Your ref: SSD-29508870-Mod-1

**Subject:** Birriwa Solar Farm

The Department of Planning, Housing and Infrastructure – Crown Lands has reviewed the Birrawa Solar Farm Modification Report.

Birriwa Solar and BESS Project - Modification
Figure 3.1

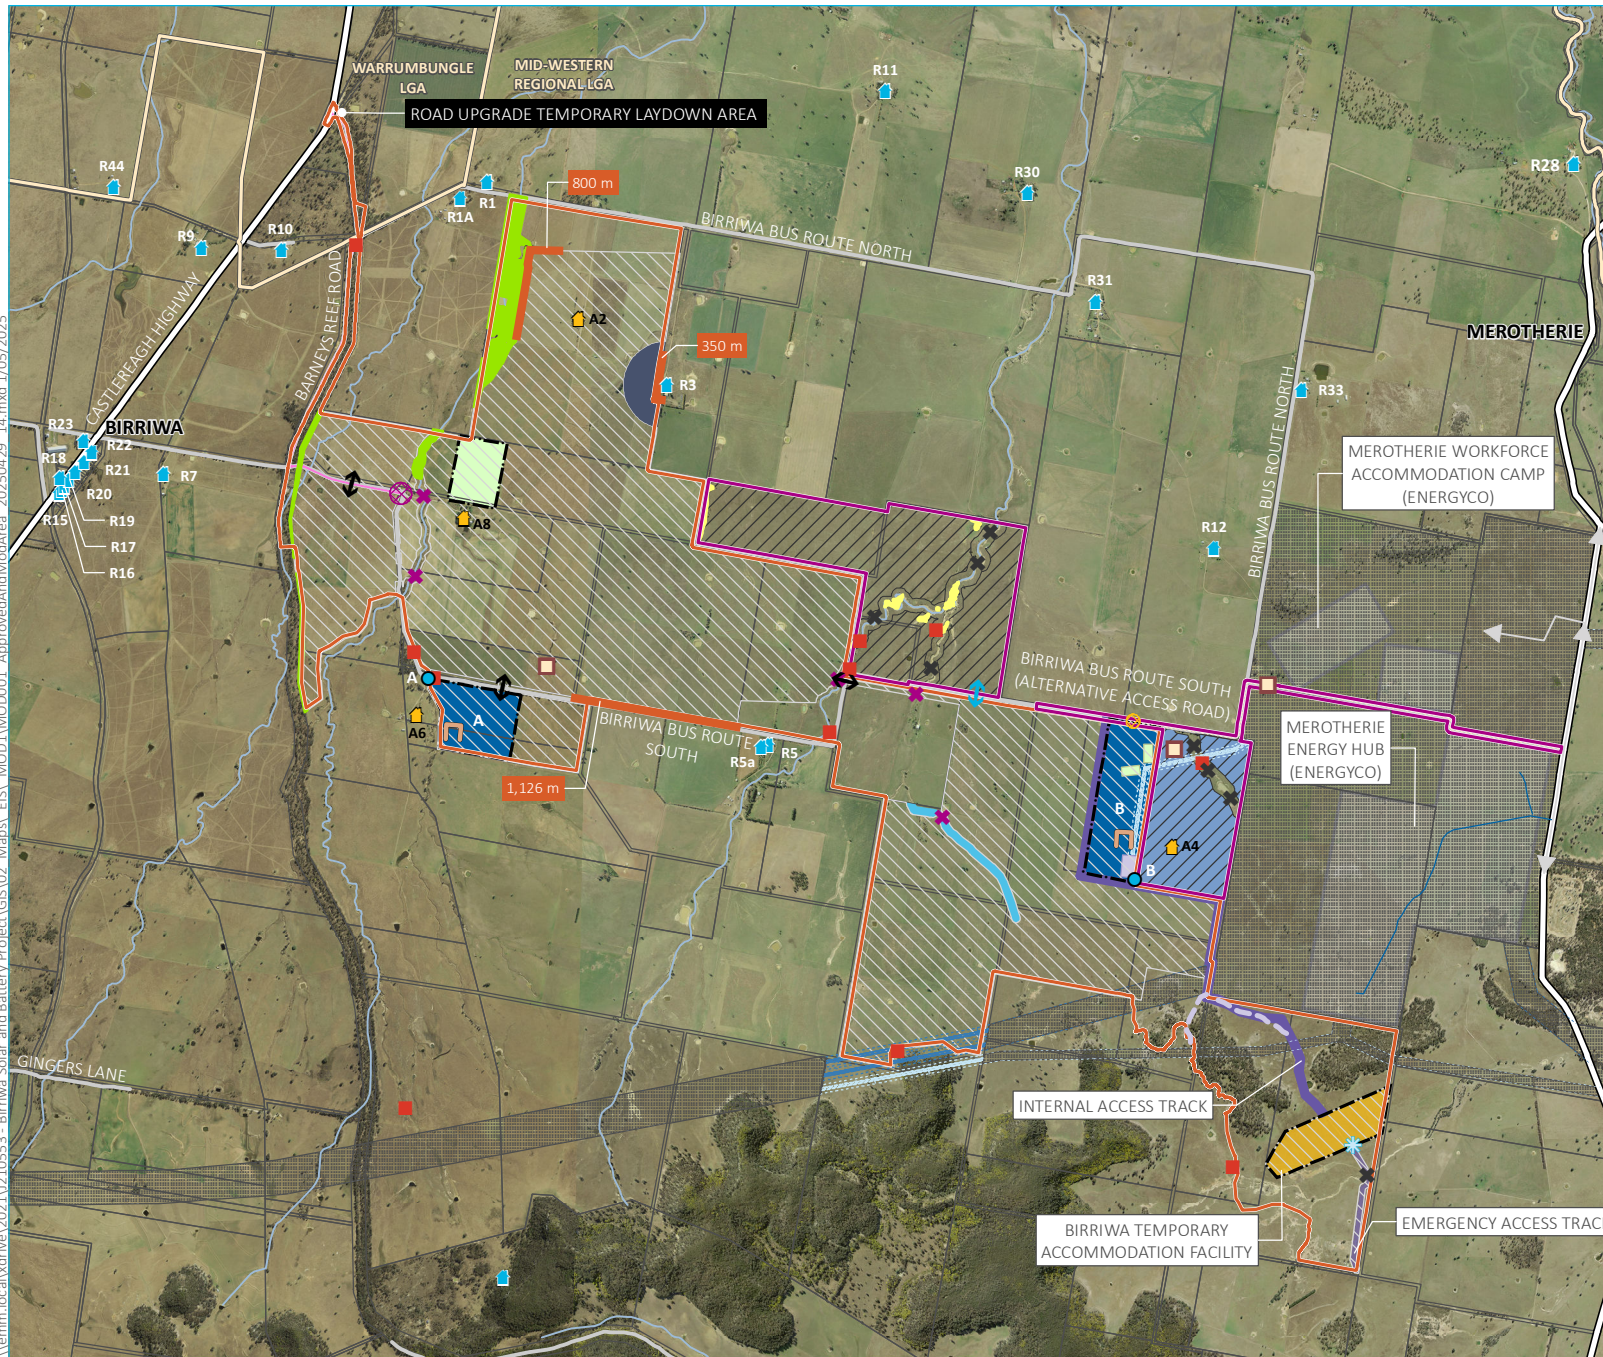
The additional areas added to the project footprint do not contain Crown land, roads or waterways. However, Crown roads adjoin the added Lots 11 and 40 DP750755 to the project site.

While no direct impact is anticipated, it is recommended that appropriate measures are taken to ensure no encroachment or unintended impacts occur on the adjoining Crown roads.
